# KITTITAS COUNTY

**TO:** All Staff  
**FROM:** Public Works Plan Review Team  
**DATE:** August 22, 2022  
**SUBJECT:** BL-22-00019 Groeschell

PRELIMINARY BOUNDARY LINE ADJUSTMENT	
PREPARED FOR A PORTION OF THE SW 1/4 OF THE SE 1/4 OF SECTION 36, TOWNSHIP 20 NORTH, RANGE 15 EAST, W.M.	
DWN BY	KITITAS COUNTY WASHINGTON
DATE	JOB NO.
07/2022	21215-1
G.W./C.R.	SCALE
CHD BY	1" = 60'
C.R./D.L.P.	SHEET
	1 OF 2

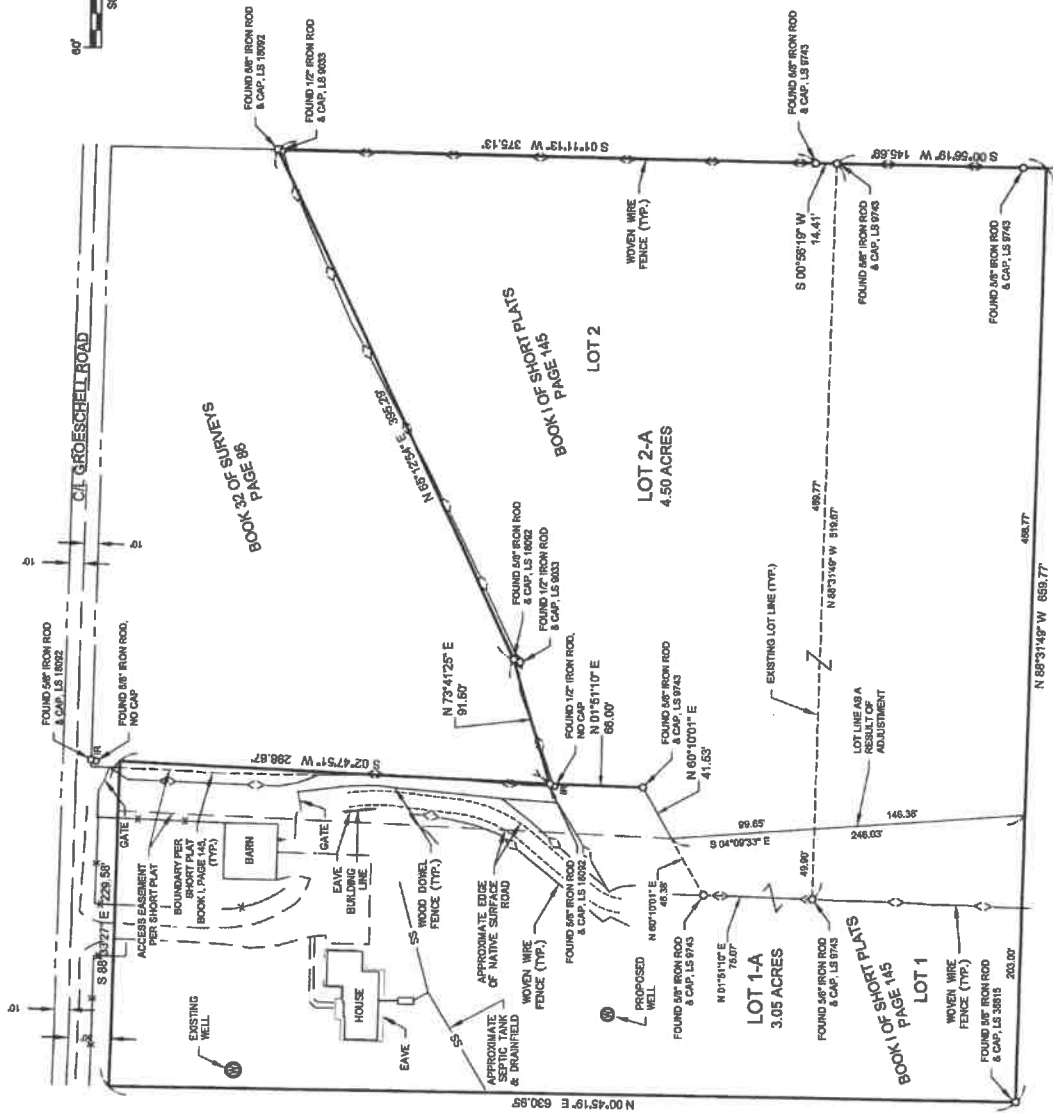
<b>SURVEY</b>	<p>As the provided map is just a site plan and is not a survey submittal, the following is offered as general guidance for the subsequent survey, and is NOT a list of requirements.</p> <ol style="list-style-type: none"> <li>1. Purpose, basis of bearing, survey and auditors statements are to be added.</li> <li>2. The 30' offset distance from center of Groeschell Rd is obscured by crossing linework.</li> <li>3. There are multiple occurrences of double monumented corners. Please include offset distances to these corners OR make reference in Legend. (EX: Fnd ½" Iron Rod 0.21'S, 0.45'W, Not accepted) OR (EX: Legend: Corners set by LS#9033 Not accepted, and shown only for reference)</li> <li>4. Please include the offset distance to the corner located near the SE corner of Parcel 2-A.</li> <li>5. it would reduce confusion if Lot 1 and Lot 2 labels were rotated to match the Book and Page info. (JT)</li> </ol>
